Application for a Non-Material Amendment Following a Grant of Planning Permission

Approval of reserved matters following outline consent AL/129/21/OUT for 93 No. residential dwellings with associated parking, landscaping, open space (including play areas), infrastructure and works

AL/143/24/RES

Rev	Description	Date	Drawn	Chk'd
Building Heights Plan - Phase 1				
Project: Ladbroke Road Woodgate				
Client(s): BDW Southampton				
Drawn No:	ST-22-06	Rev:	N	
Scale:	1:500 @ A0	Date:	23/07/2024	
Drawn By:	SW	Checked By:	-

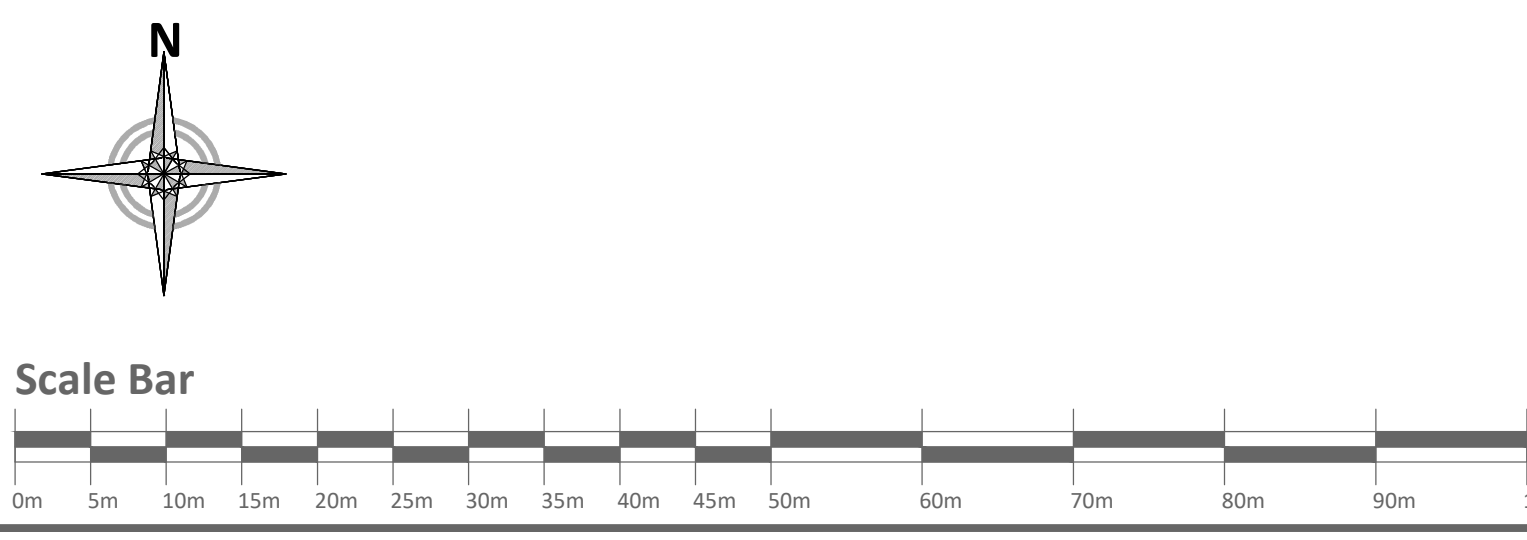
- Amendment to paths north of Plots 26 & 27 and east of Plots 27-16, to reduce the width to 2m for pedestrian use, associated with the delivery of a 2m footway along Lidsey Road (path around Plot 15 provided as 3m)

- Amendment to path north of pumping station and east of sub-station, to increase width to 3m for shared pedestrian/cycle use (on opposite side of spine road to Plots 43-48), with directional signage for cyclists
